Accessibility Report – DA Submission

Project Title: Proposed Mainfreight Expansion Facility
Prestons Distribution Centre
26 Yarrawa Street, Prestons

Date: 20 February 2013

DESIGN REVIEW – DA Stage

**Bldg 2 - Ground Floor Plan**  
1:250 (A1) / 1:500 (A3)  
Feb 2013  
**4167\_DA015**  
10m

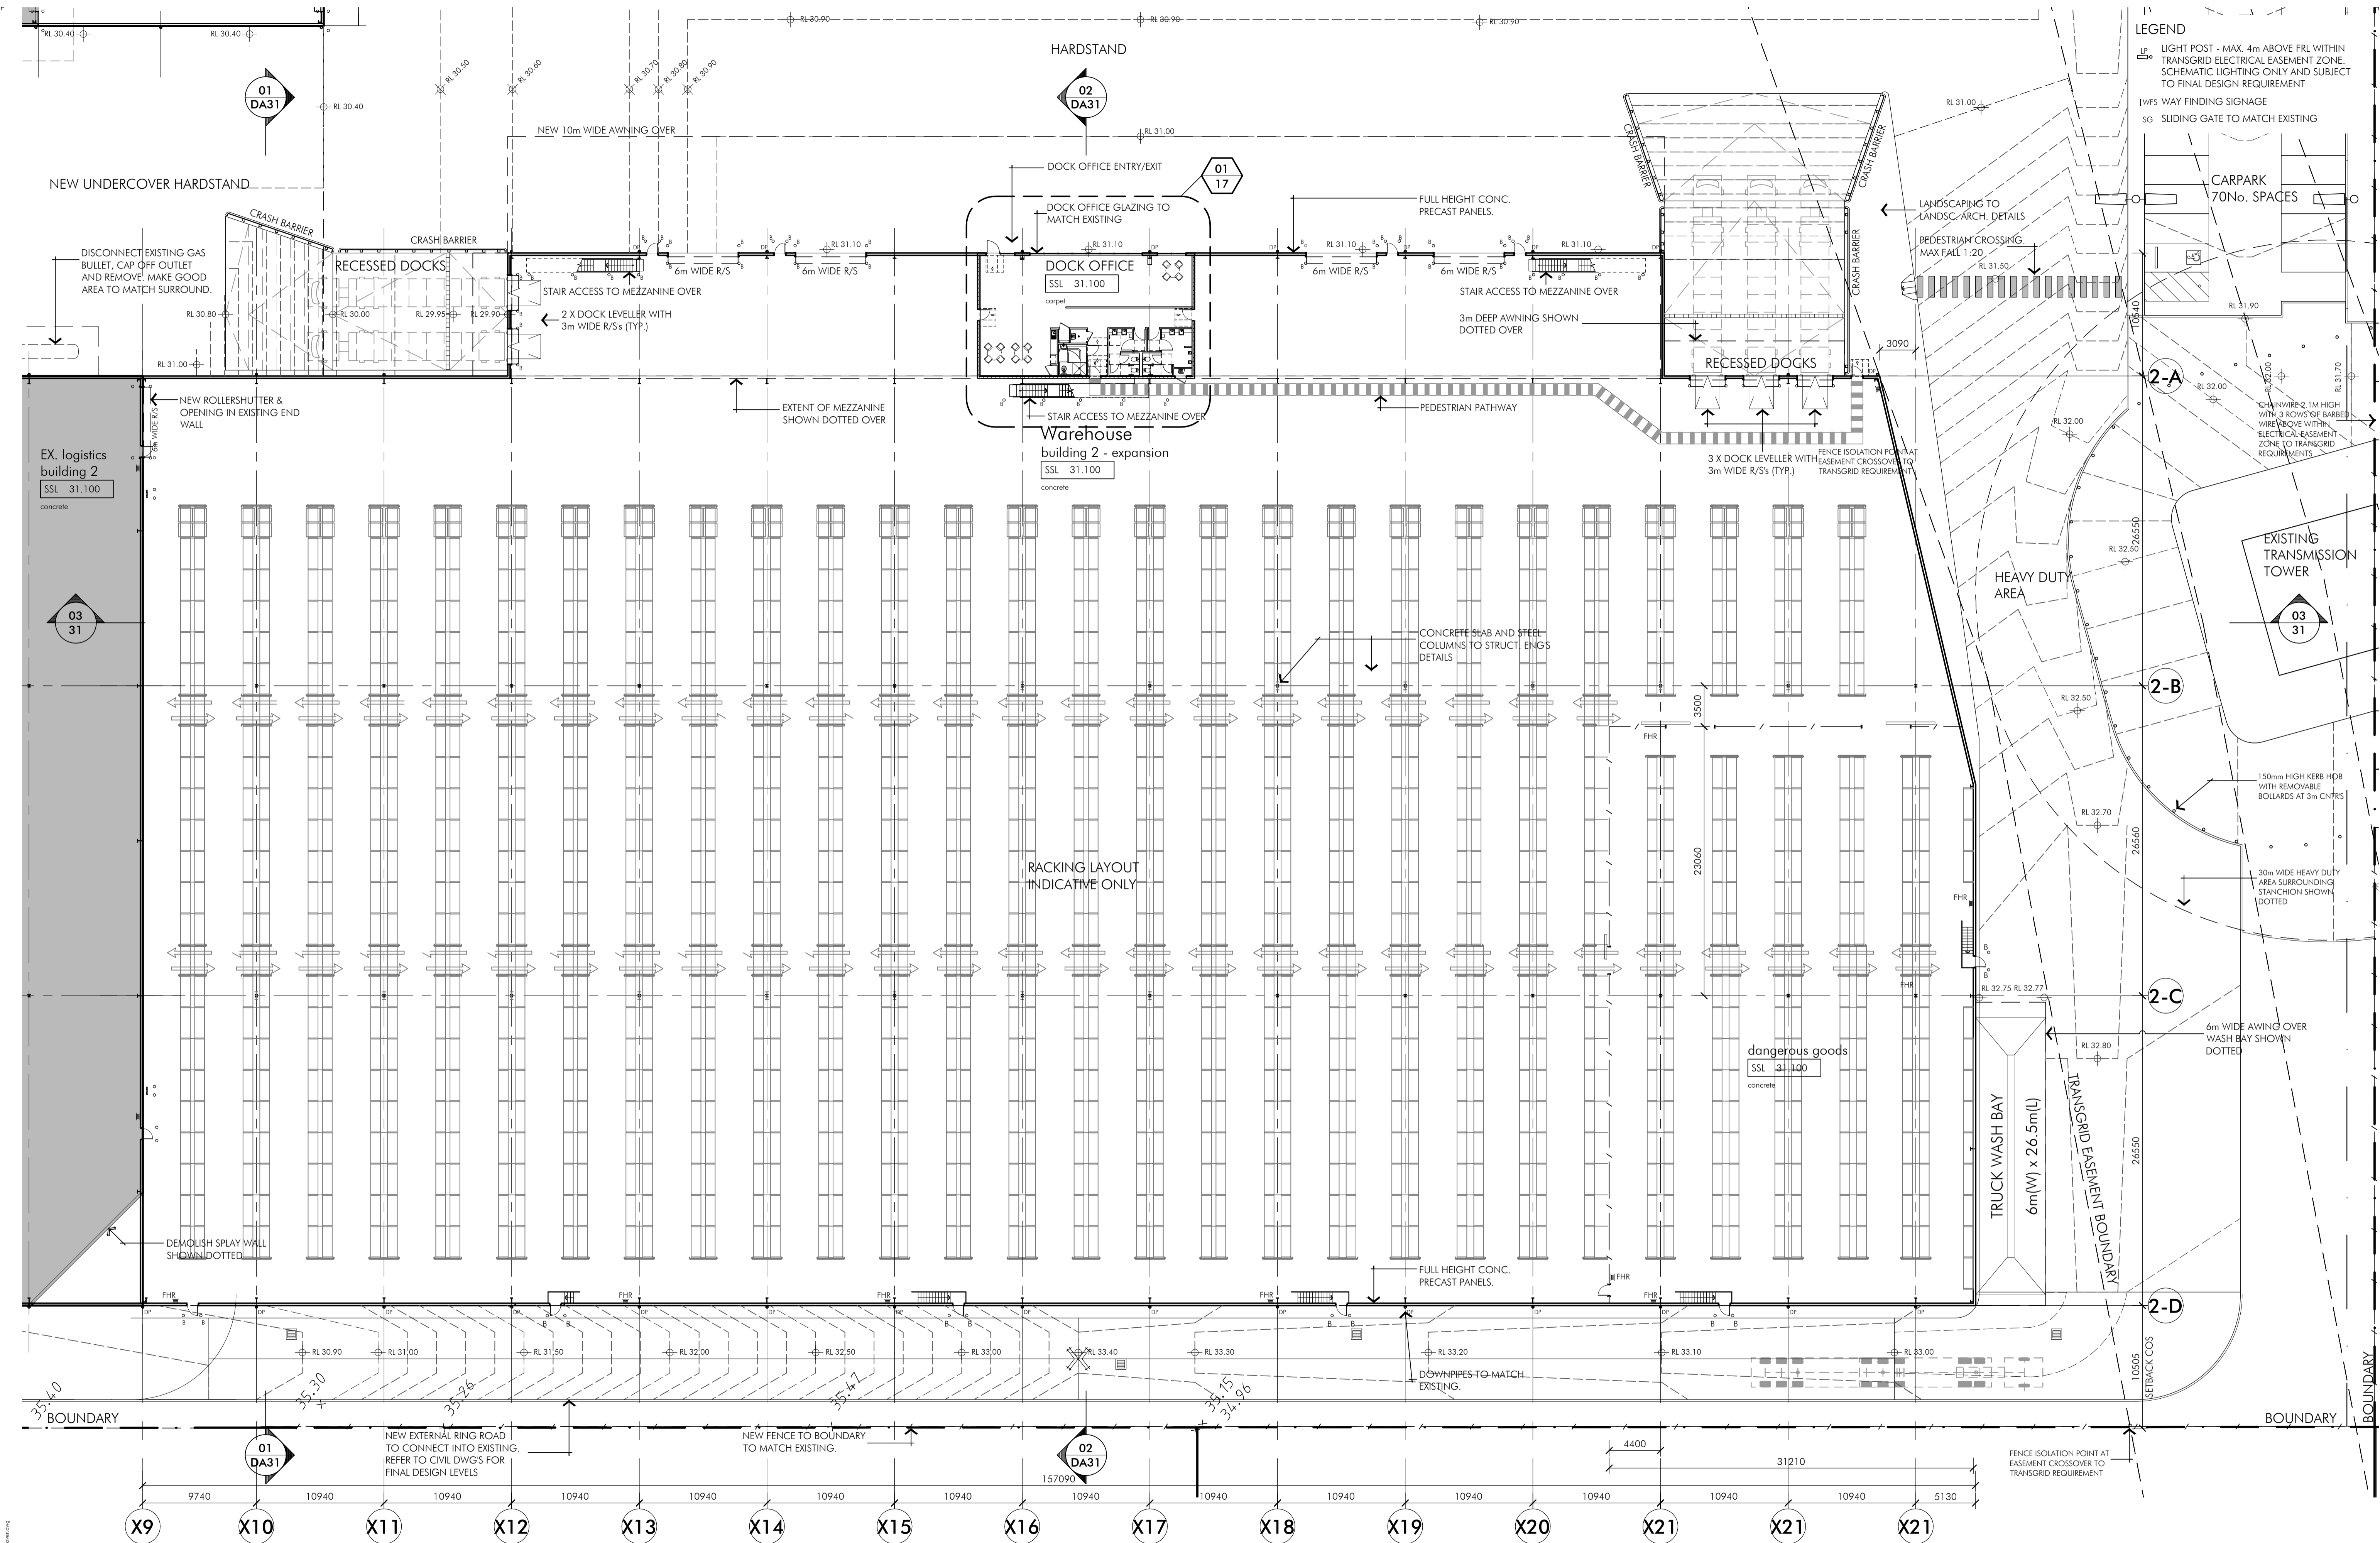
DWG No	Comment/Issue(s)	Recommendation(s)	Compliance Achieved
DA15	The principal pedestrian entrance is provided via the carpark area using a pedestrian crossing which will be designed to compliant grade which leads to the dock office.	Further review will be carried out at detail design stage	YES
<i>Key entrance recommendations</i> - Main entry must be accessible - other pedestrian entrances which is are not accessible must be located within 50m from an accessible pedestrian entrance. - Entry requires single door leaf width clearance of 850mm (920mm door size). - Circulation space of 1450mm required either side of entry. Minimum grade & crossfall 1:40. - Entrance doors to have operational weight of less than 20N of force or be automated. - All frameless glazed doors must be marked with contrasting marking not less than 75mm wide for full width of doors with lowest edge at 900-1000mm.

4167_DA016

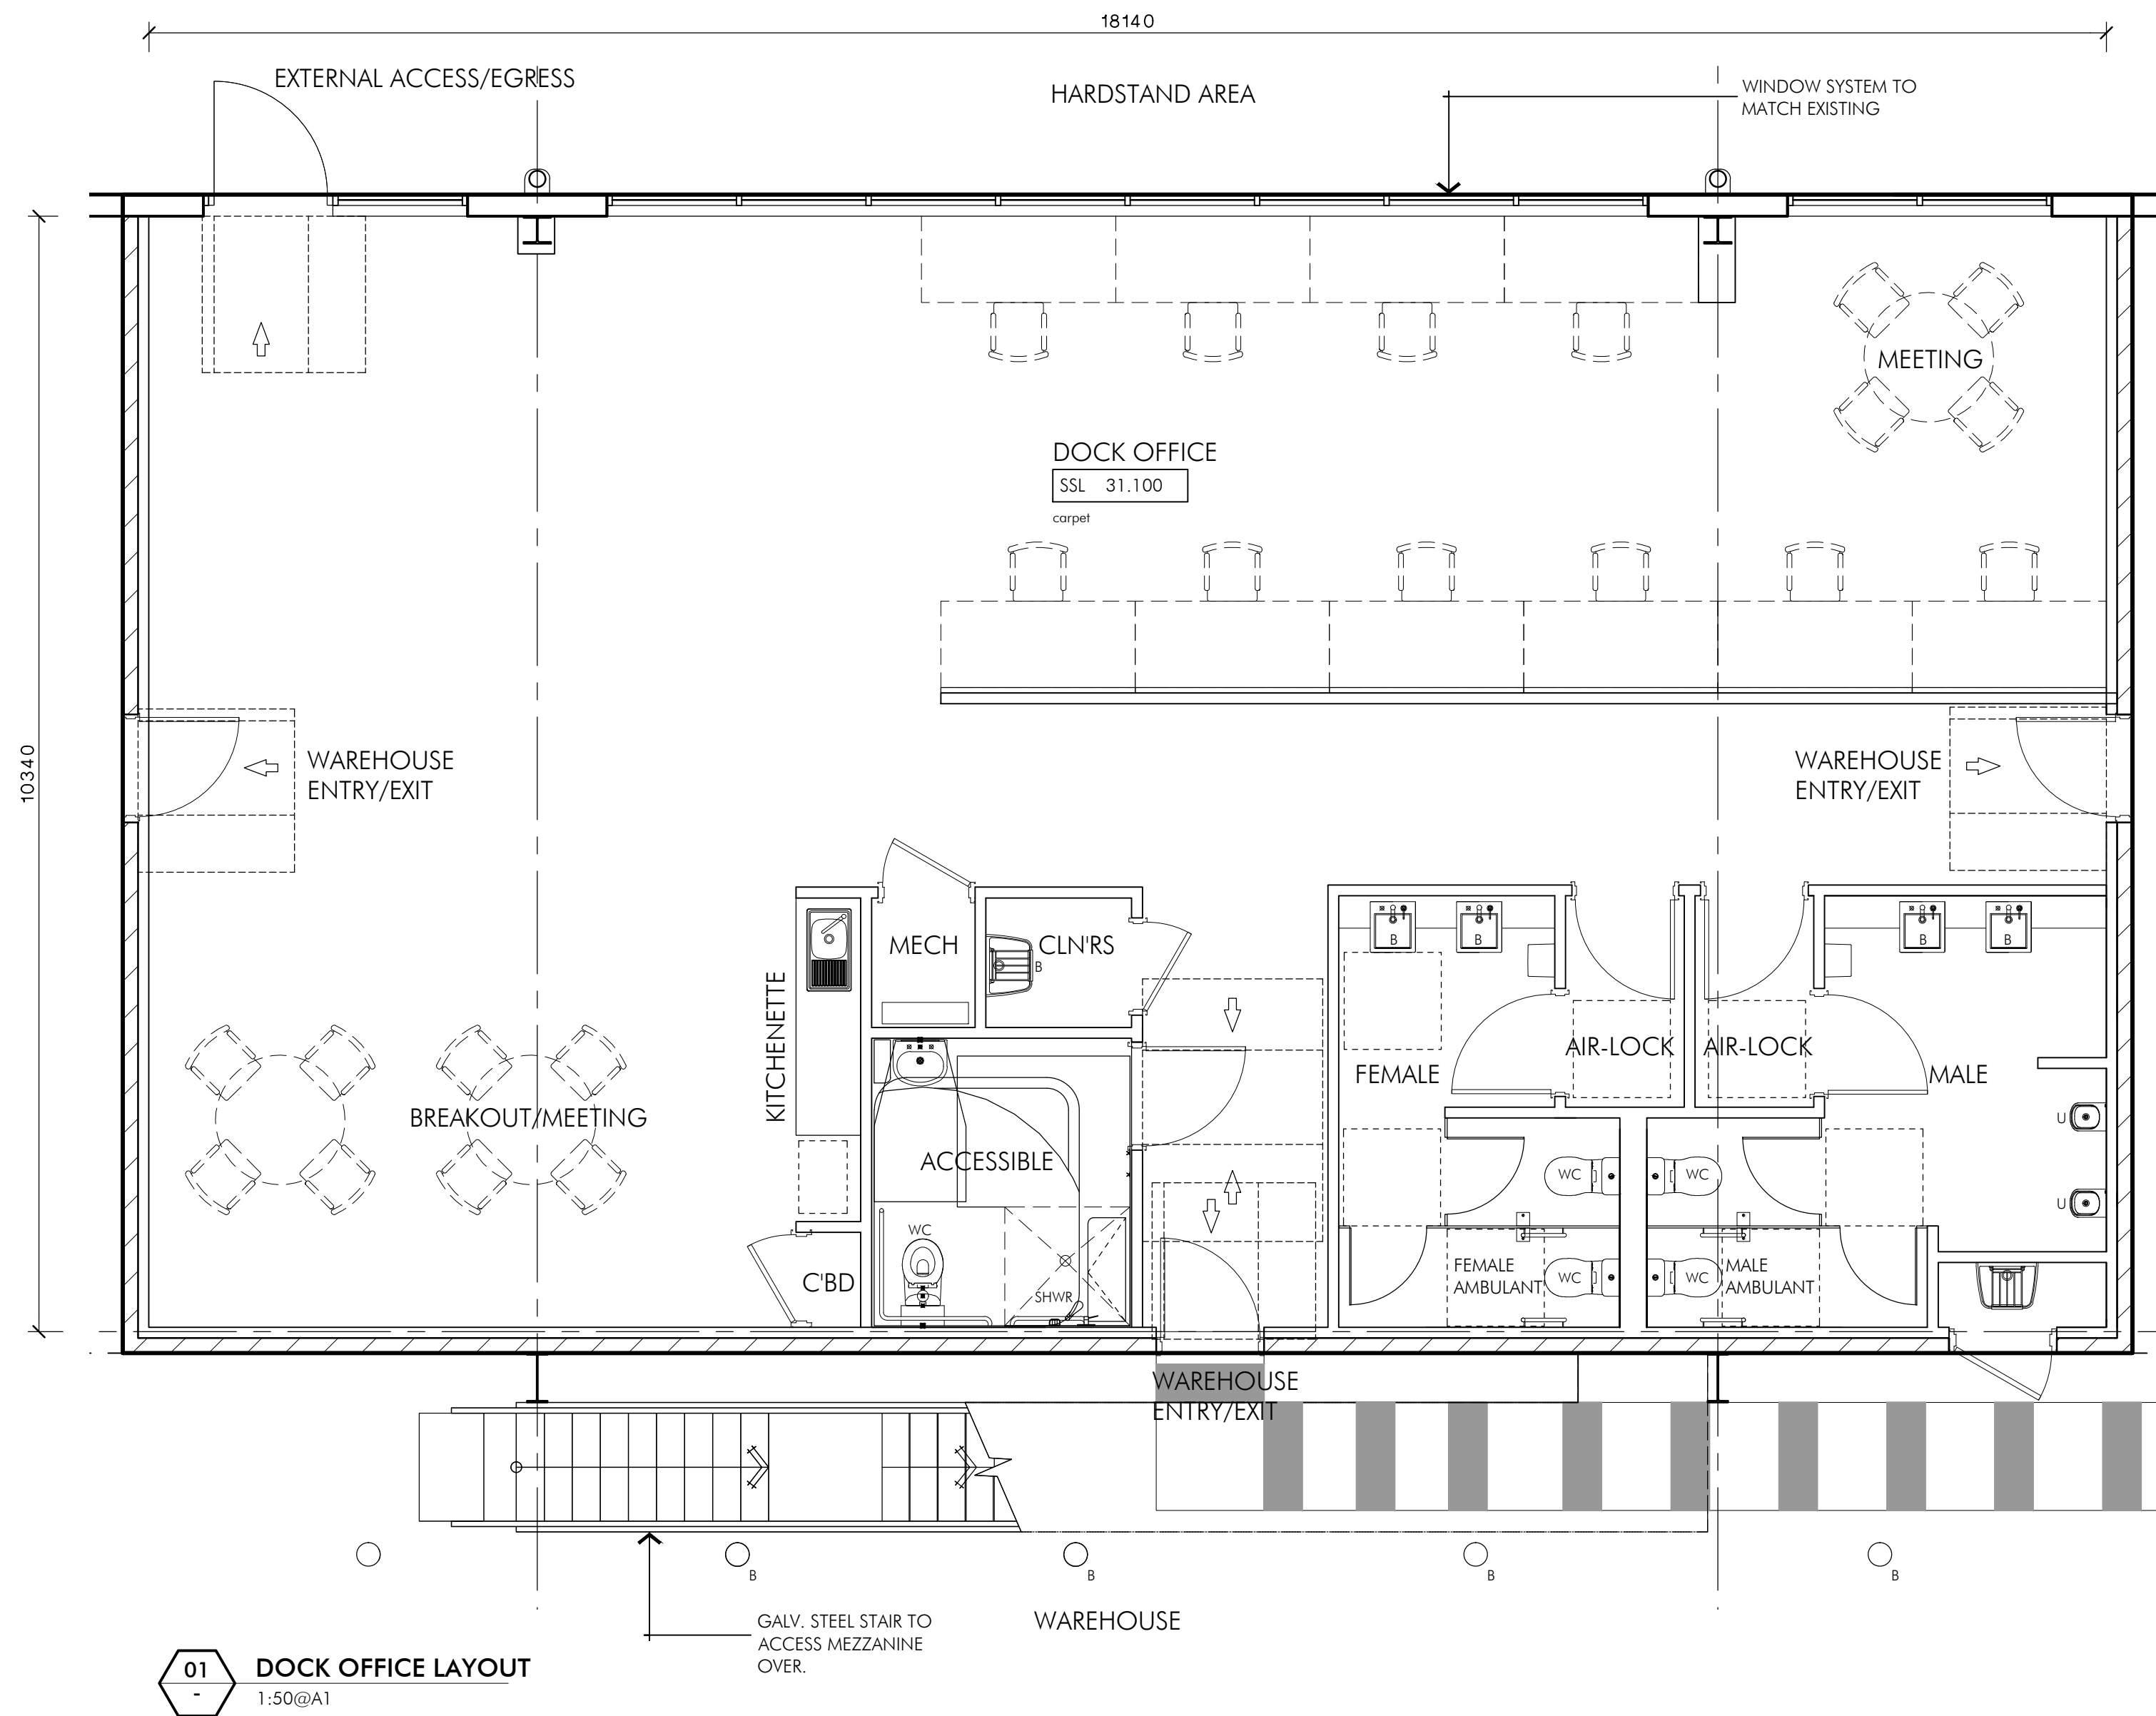
DWG No	Comment/Issue(s)	Recommendation(s)	Compliance Achieved
DA16	Stair access only is provided to the storage mezzanine area.	Further review to be carried out at detail design phase. BCA part D3.4 allows for exemptions where access would be inappropriate because of the particular purpose for which the area is used.	YES, exempt under D3.4
DA16	Stairways and ramps	- Handrails to be provided on both sides of stairs including tactile ground surface indicators. - To be reviewed at detail design stage	YES
- Common use stairs require AS1428 series compliant handrailing, tread features and TGSi. - Max gradient of a ramp exceeding 1900mm is 1:14. Gradient to be consistent throughout ramp. Landings in direction of travel 1200mm long; landings at 90° directional change 1500mm x 1500mm. Landings at 180° directional change 1540mm x 2070mm length.
